R/108/21/PL – Submission of Additional Information

Full planning application for the demolition of two dwellings and the construction of 3 No. 3-bed town houses and 7 flats. This site is in CIL Zone 4 and is CIL Liable as new dwellings at 117 Sea Lane Rustington BN16 2RU

A REV	27/10/21 DATE	Second floor removed. DESCRIPTION	18th Mar 2021		EL	
			DRAWING TITLE PROPOSED STREET ELEVATIONS 1			
			SCALE 1 : 100@ A1		DRAWING NO. P202

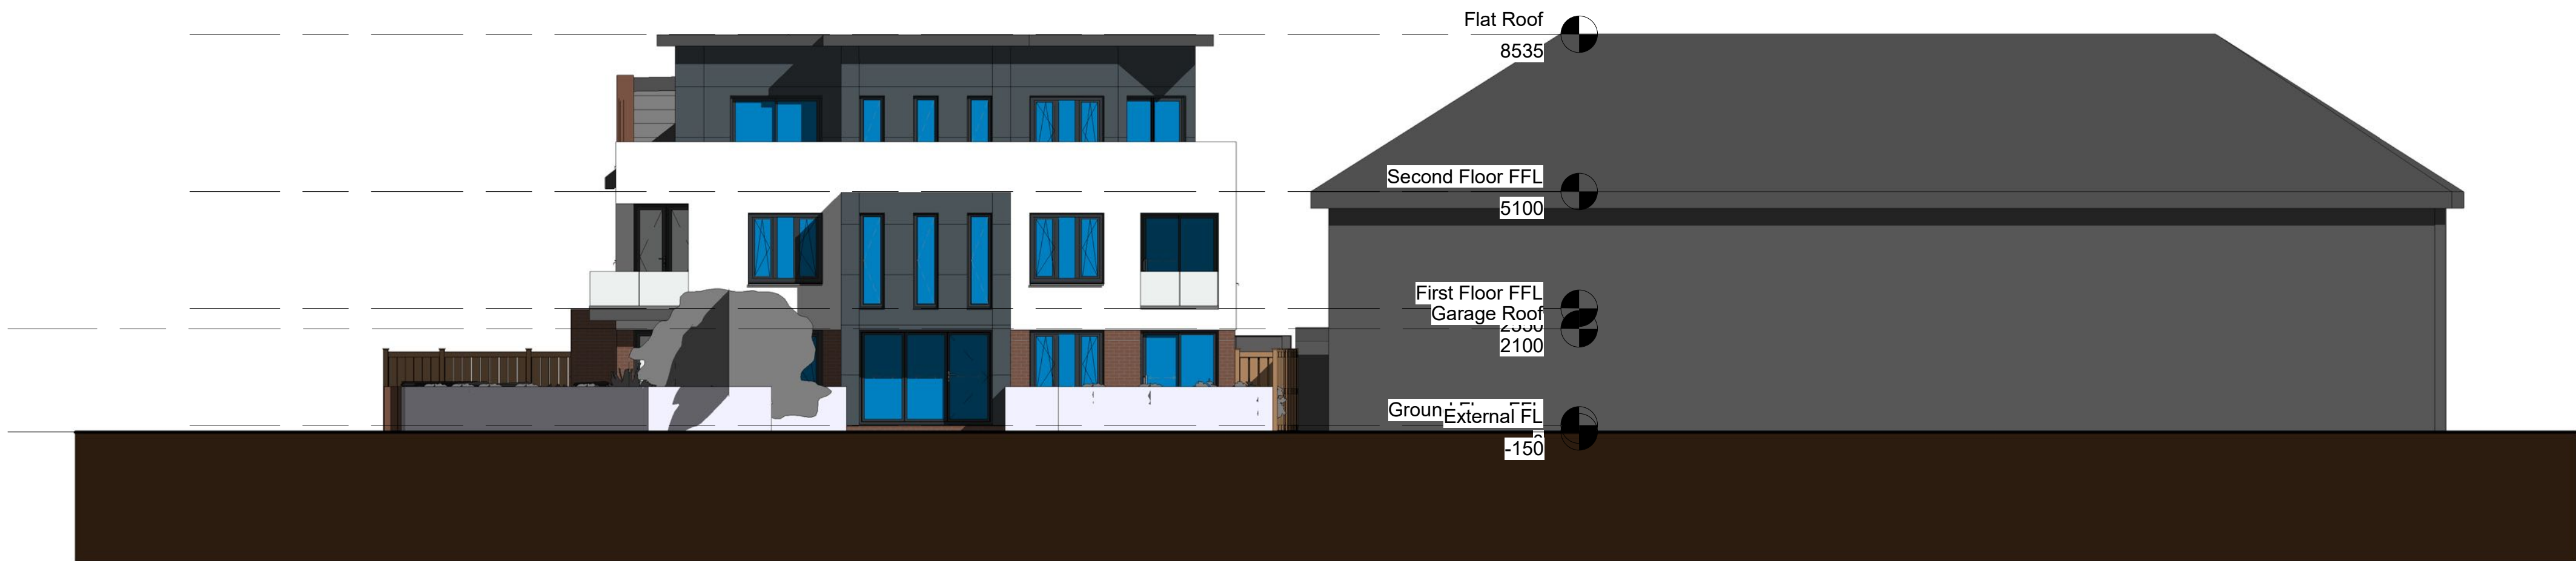
- 1. By virtue of its scale, bulk and height the development is considered to be out of character with the existing area and the absence of space around the development to provide sufficient landscaping will not mitigate this harm contrary to policies D DM1, D SP1 of the Arun Local Plan and policy 2 of the Rustington Neighbourhood Plan.*

Revised plans have now been submitted which reduces the quantum of development. The original submission proposed a four-storey block of 7 flats. The block of flats has now been revised to propose a three storey block of 5 flats. The revised elevation, as viewed from Shaftesbury Road is below.

| PROPOSED STREET ELEVATIONS 2 |               |                                    |    |

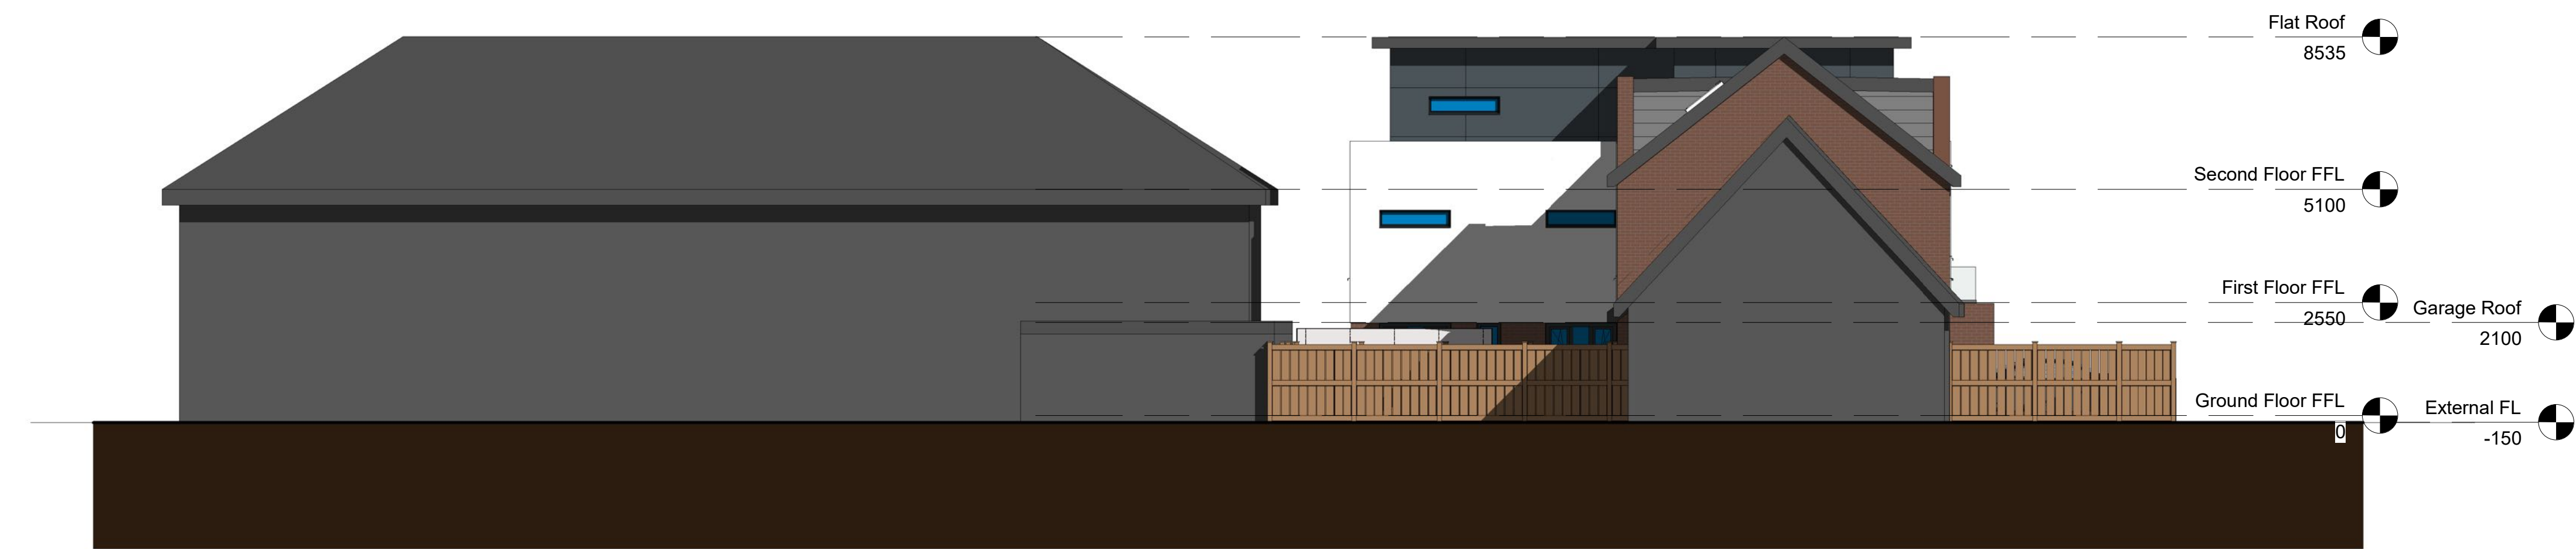
2. *The relationship of the rear windows of the block of flats and the closest town house garden is such that the proposal is overbearing and result in unacceptable overlooking contrary to policy D DM1 of the Arun Local Plan.*

Revised plans show a redesign of the layout of the 1st floor flat to remove potential overlooking. The new windows on the revised elevation are high level.
